Two storey pitch roof extension with alterations to existing
2 New Cottages Shripney Road Aldingbourne PO22 9PF

**Two storey pitch roof extension with alterations to existing
2 New Cottages Shripney Road Aldingbourne**

I regret that I am unable to accept your documents as a formal application until the following matters have been resolved :-

Existing Roof Plan 1 : 100

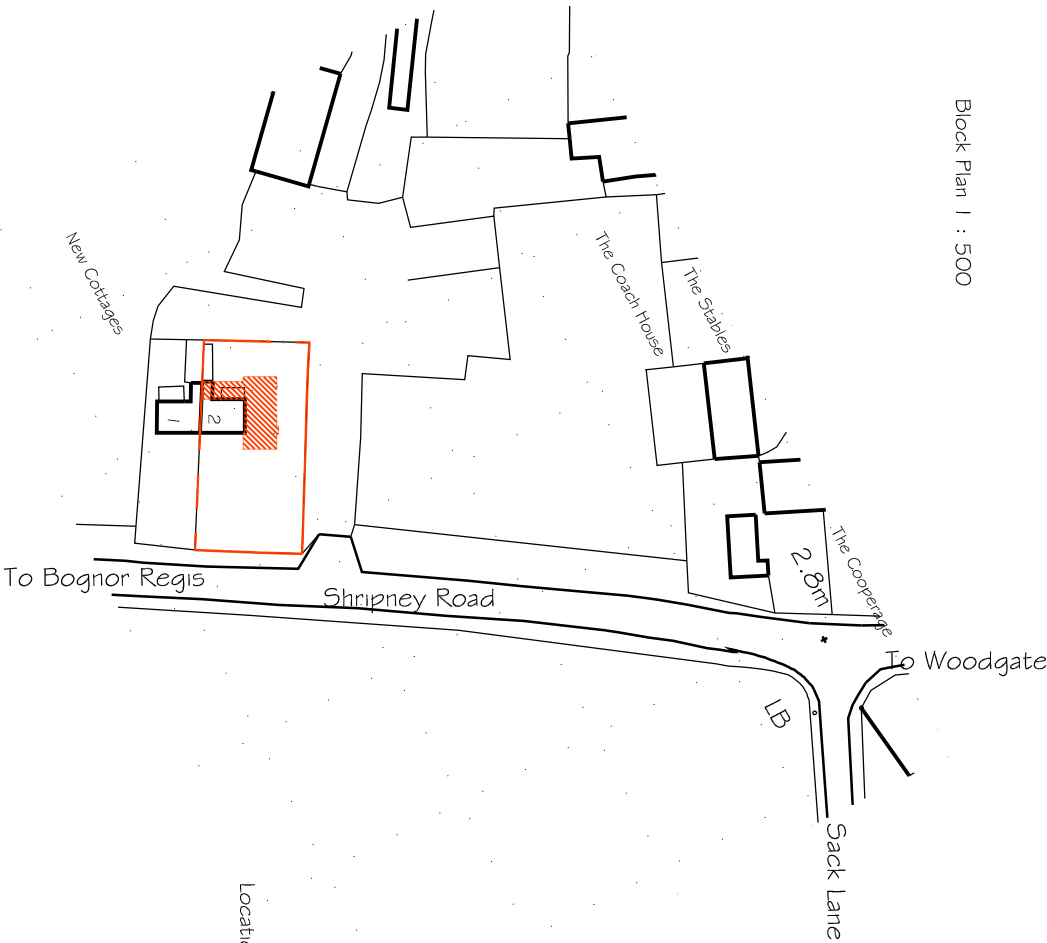
Please submit 1 electronic or 3 paper copies of existing roof plan in accordance with guidance notes available on our website detailed below (click on National List). ==>

Title
Elevations as Proposed

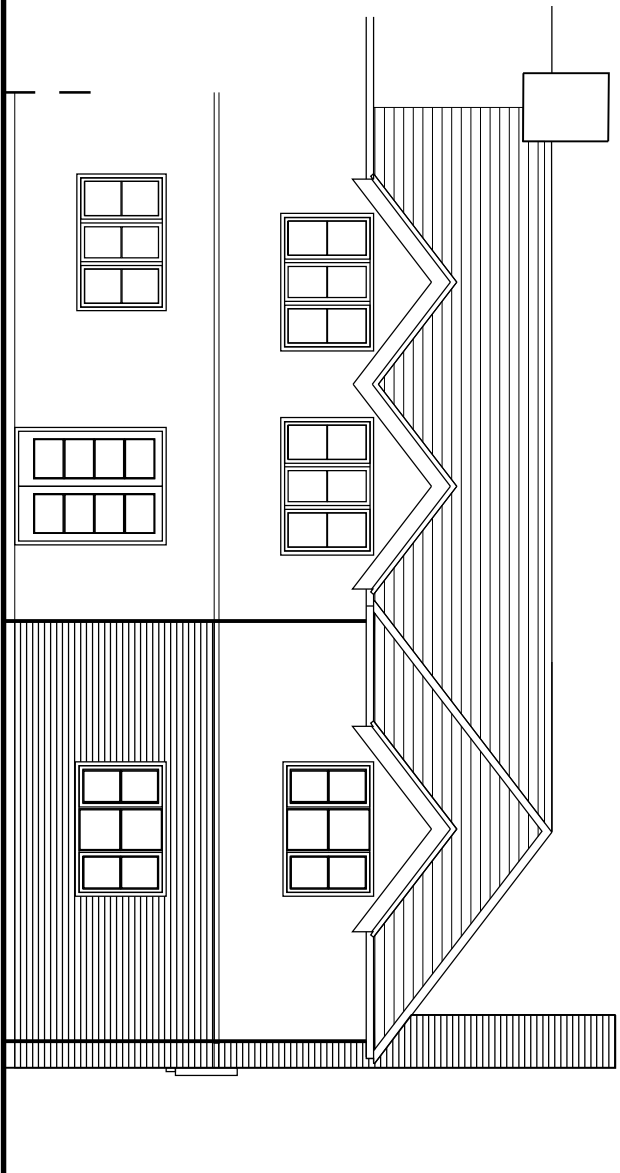
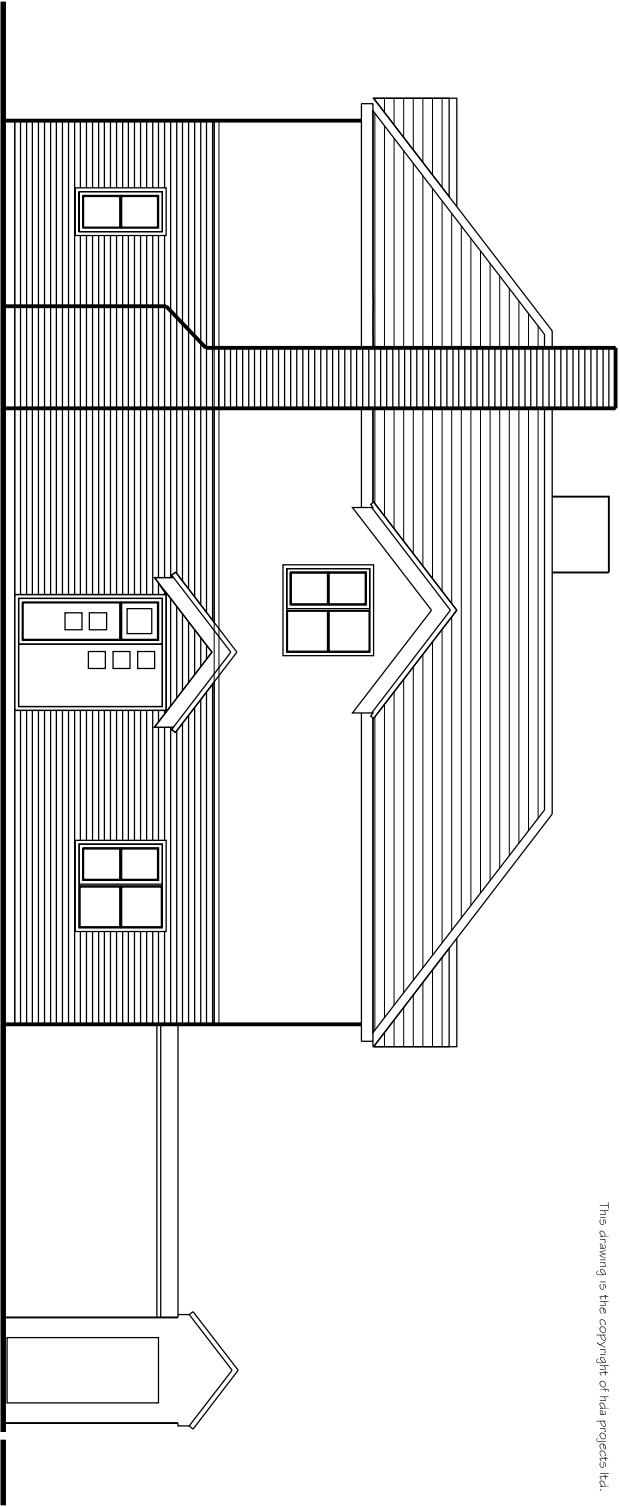
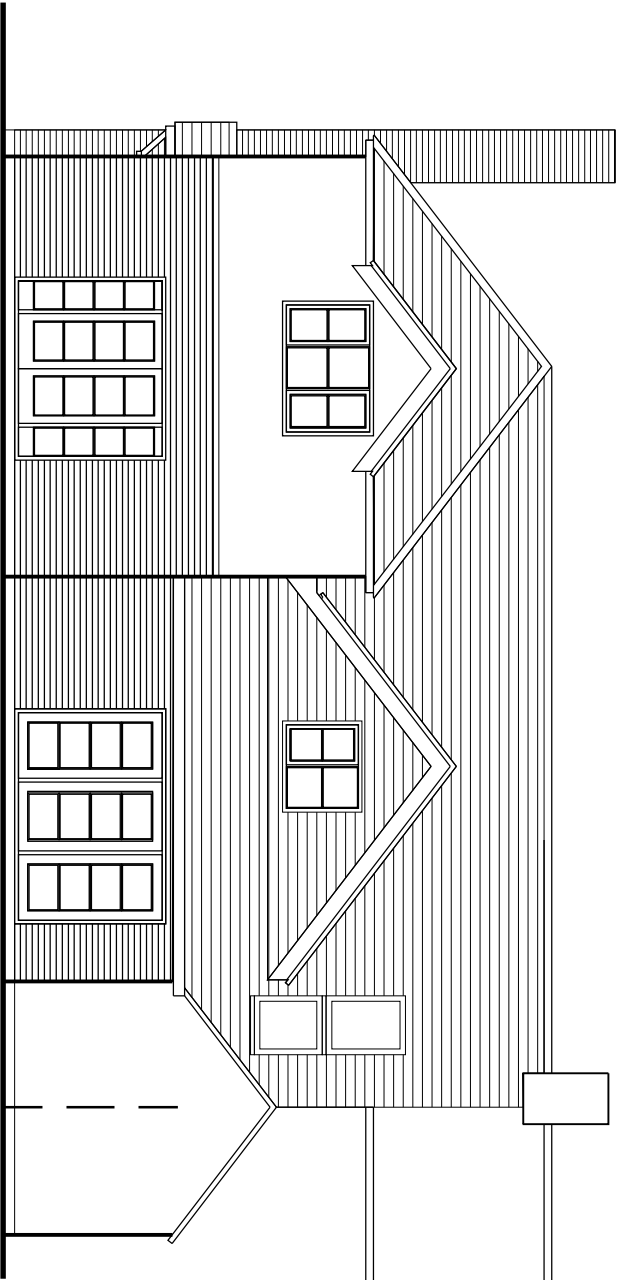
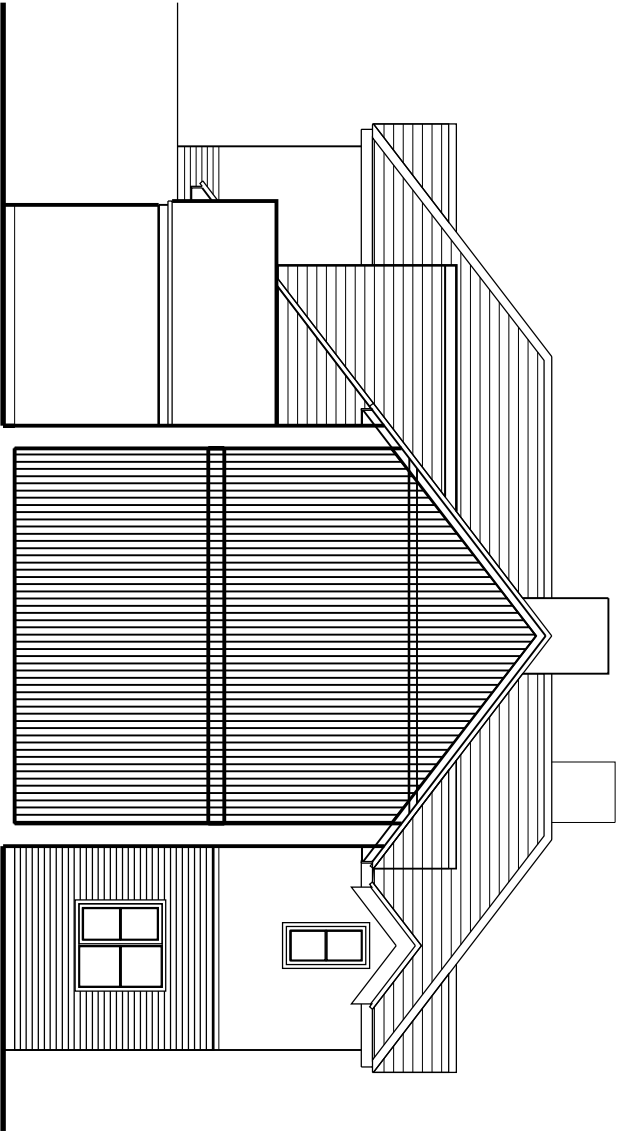
Please provide 1 electronic or 3 paper copies of existing and proposed South West elevations in accordance with the guidance notes available on our website detailed below (click on National List).

Two proposed elevations have been labelled 'North West' ~~Please amend accordingly.~~
